Date: 24 November, 2015

Re: Application: SSD 6624
described as "Sly's Quarry Expansion Project"
Applicant: Newman Quarrying Pty Ltd
Location: Jacky Bulbin Road, Tabbimoble Creek, NSW

**Figure 1** Site location and noise sensitive receivers

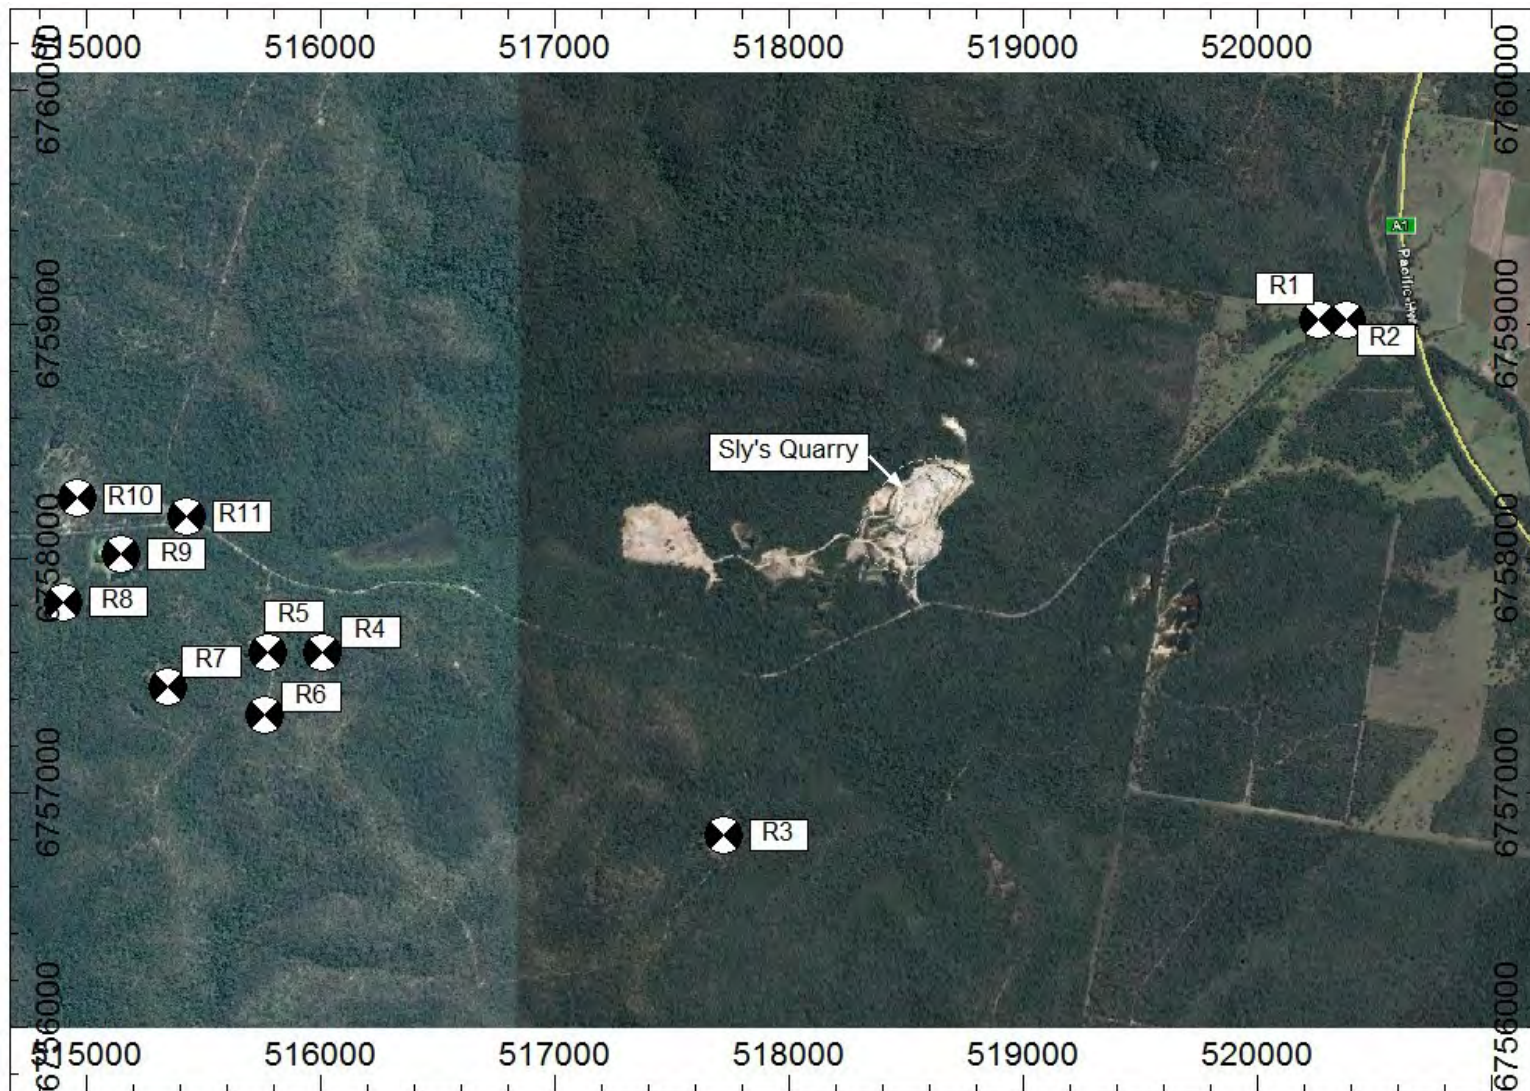
Inspection of Figure 1 in EIS Appendix D - Noise Assessment shows that the receiver presumably referred to as being 1.5 kms from the quarry site appears in fact to be more than 1 km west of our entrance drive and sheltered behind a ridge on our western boundary that rises to about 120 metres AHD.

No request was made to us for measuring instruments to be placed on our property and from inspection of Figure 1 none appear to have been placed there.

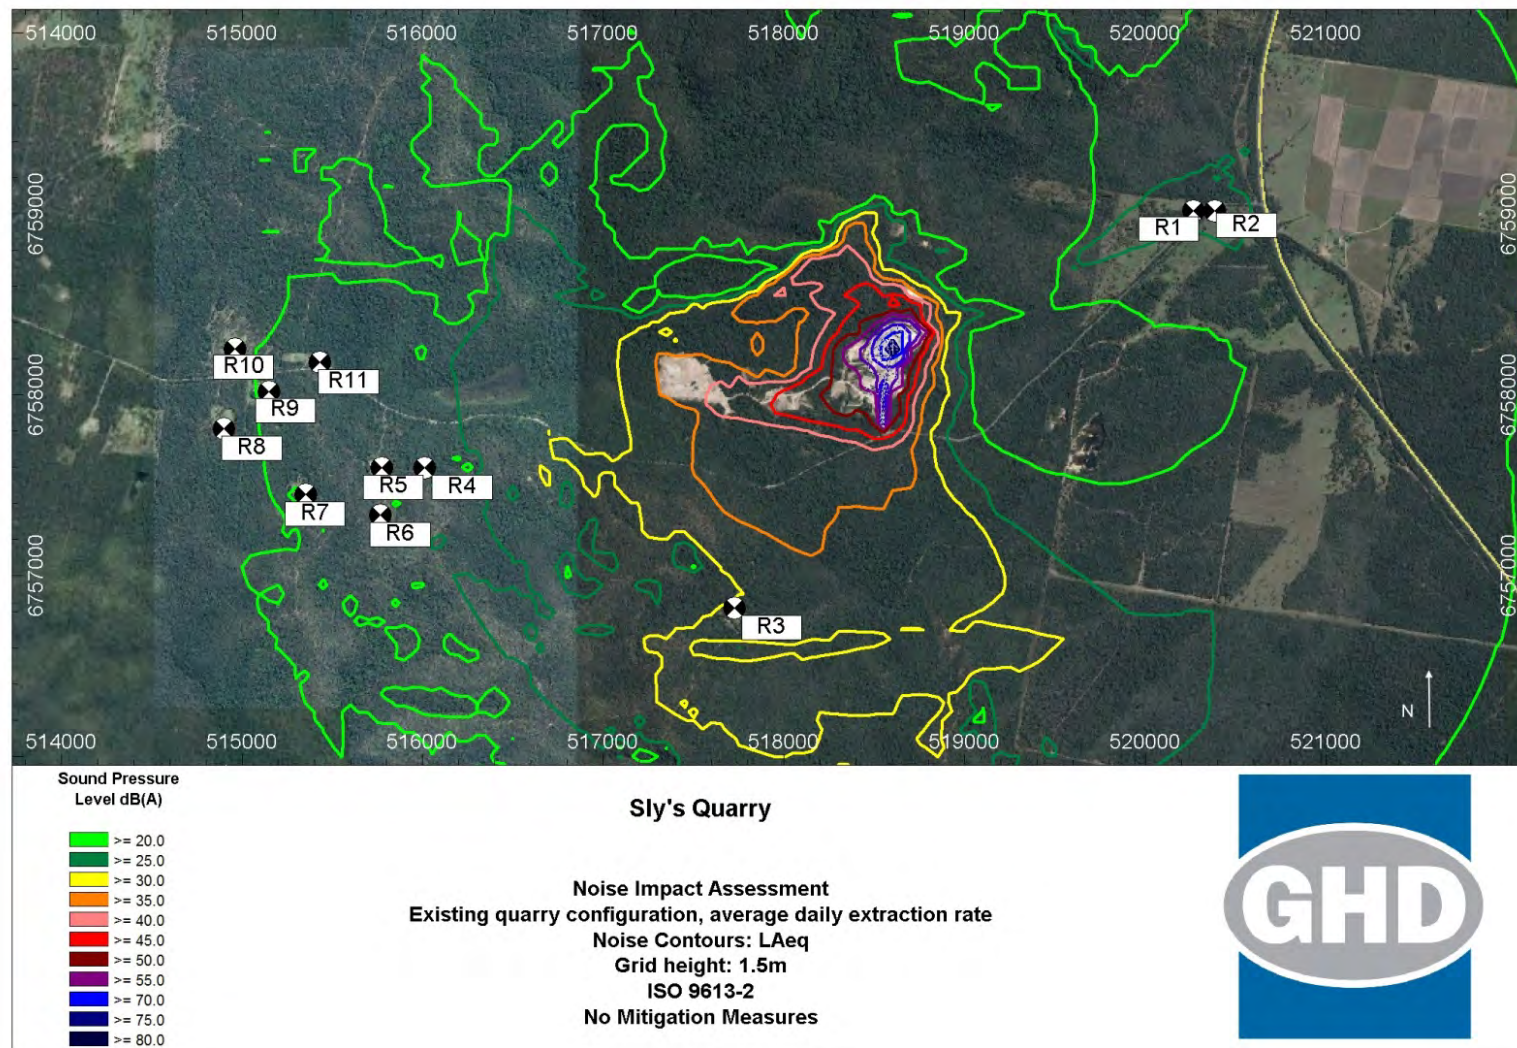
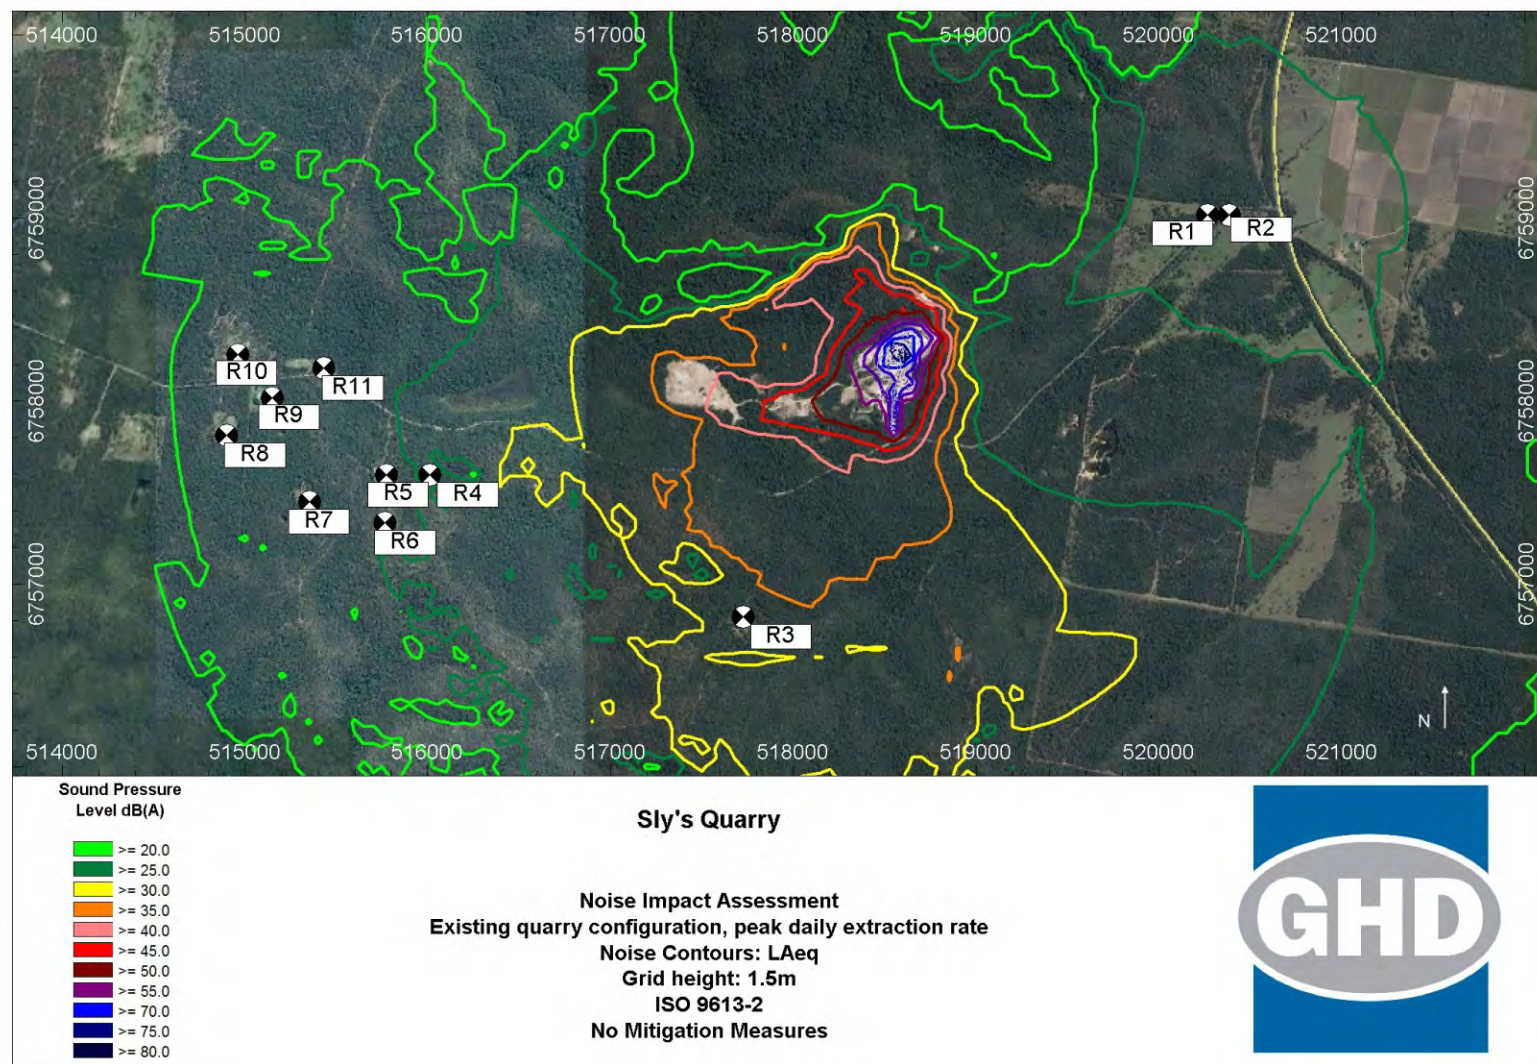
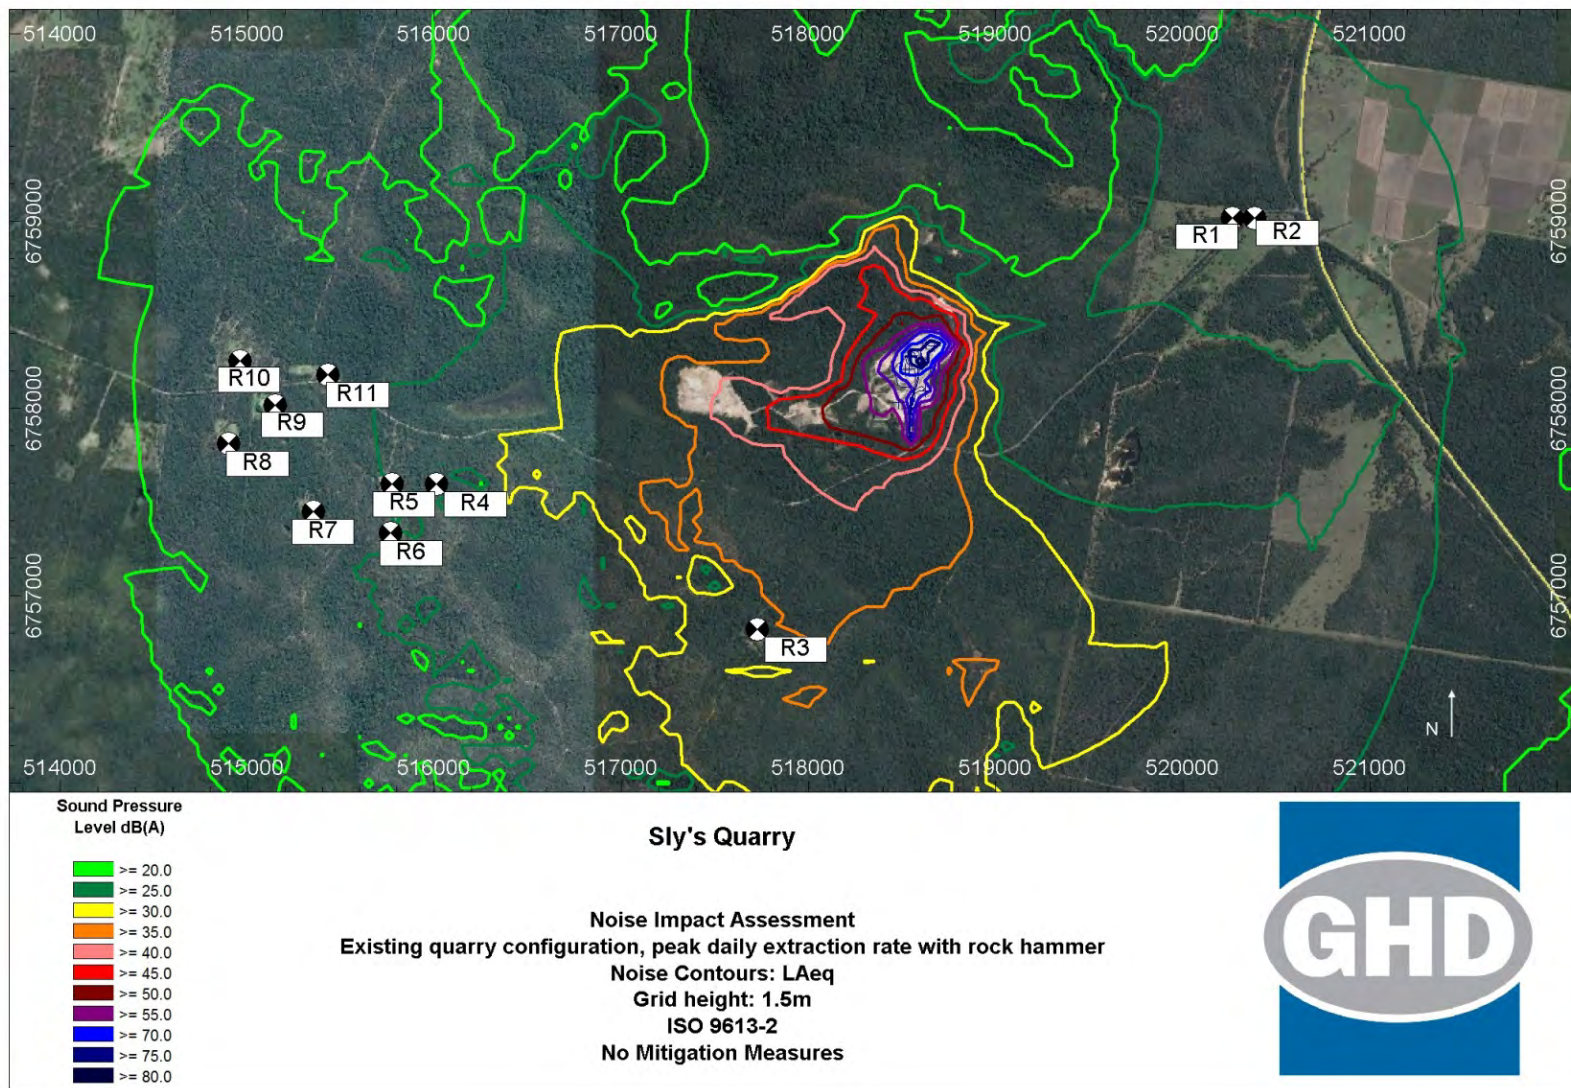
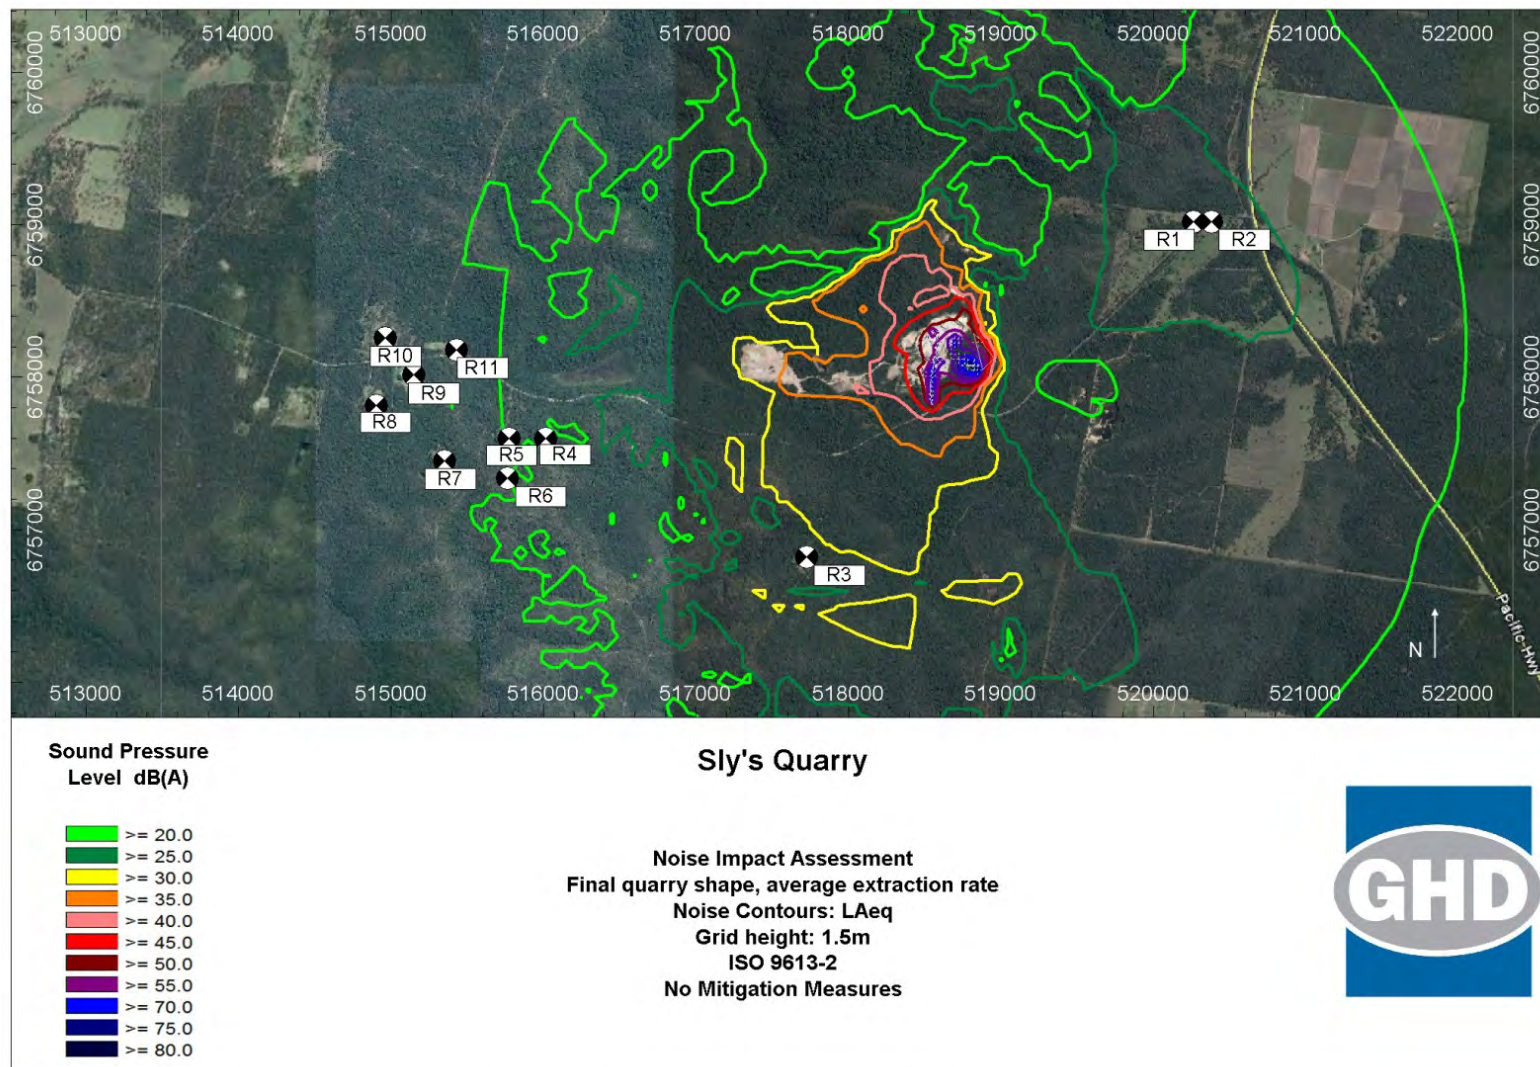
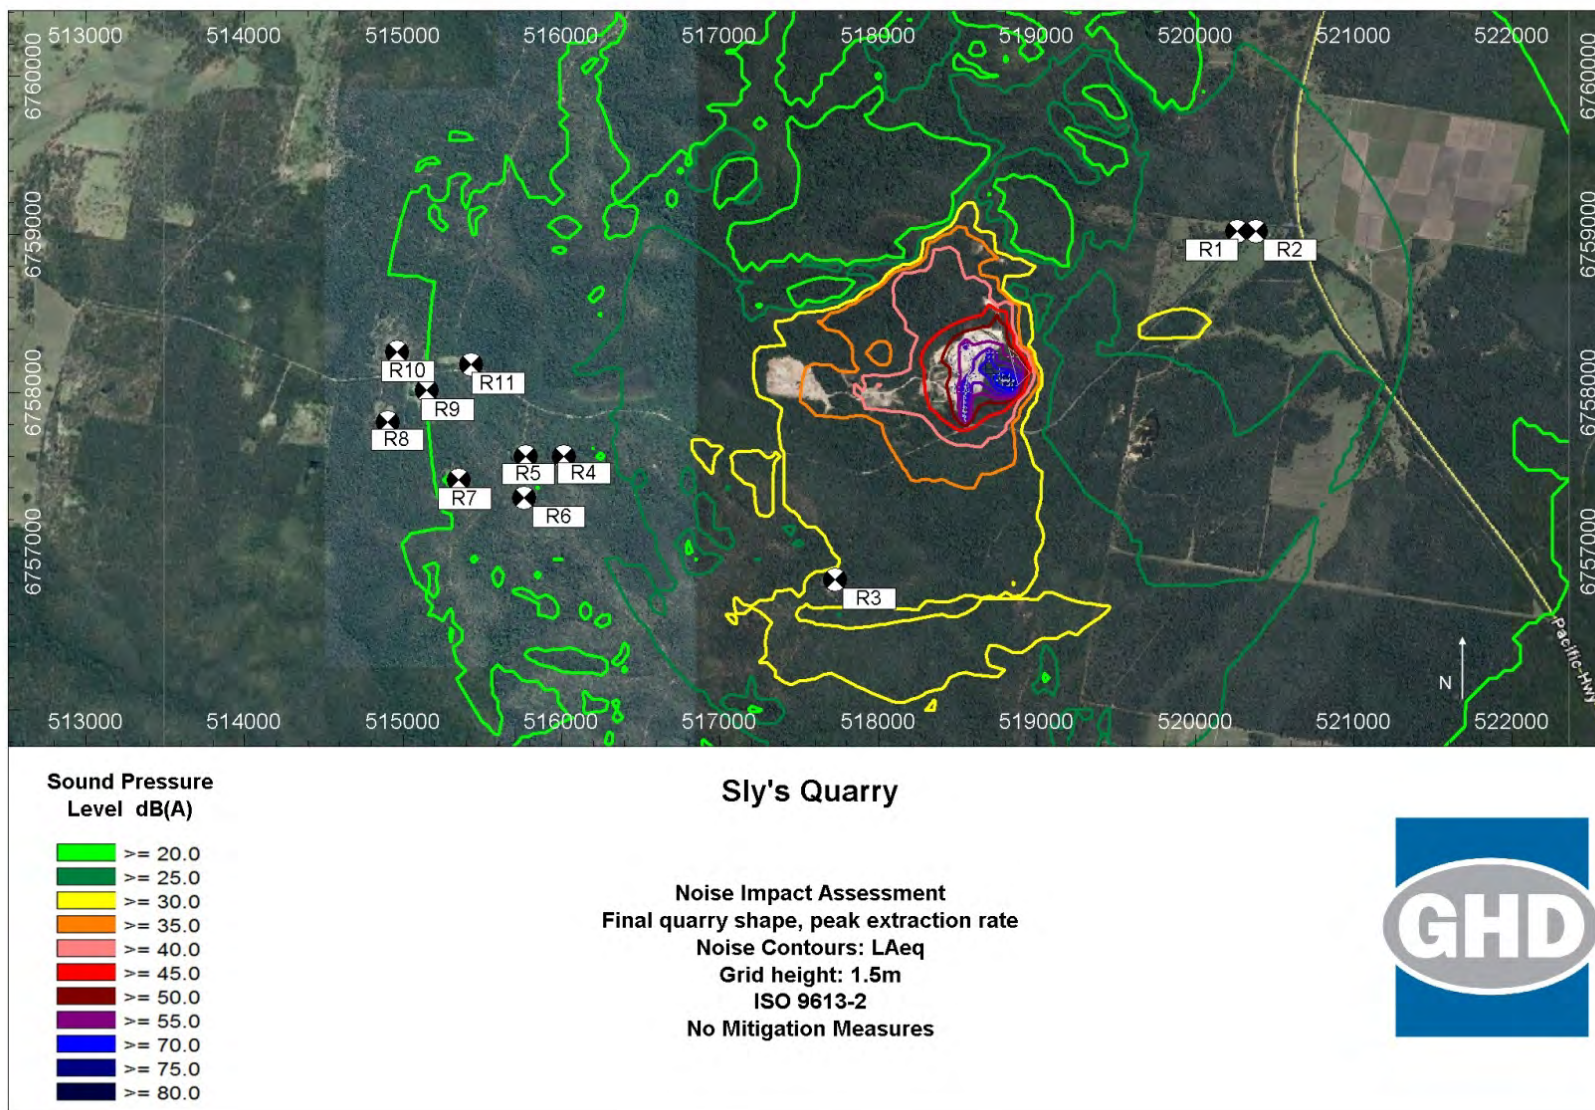
Inspection of Table 5.2 and Figures 4 to 9 in EIS Appendix D - Noise Assessment leads us to conclude that even without direct measurements, that noise levels may well far exceed the requirement to be no greater than 5 dB above background levels at the property boundary.
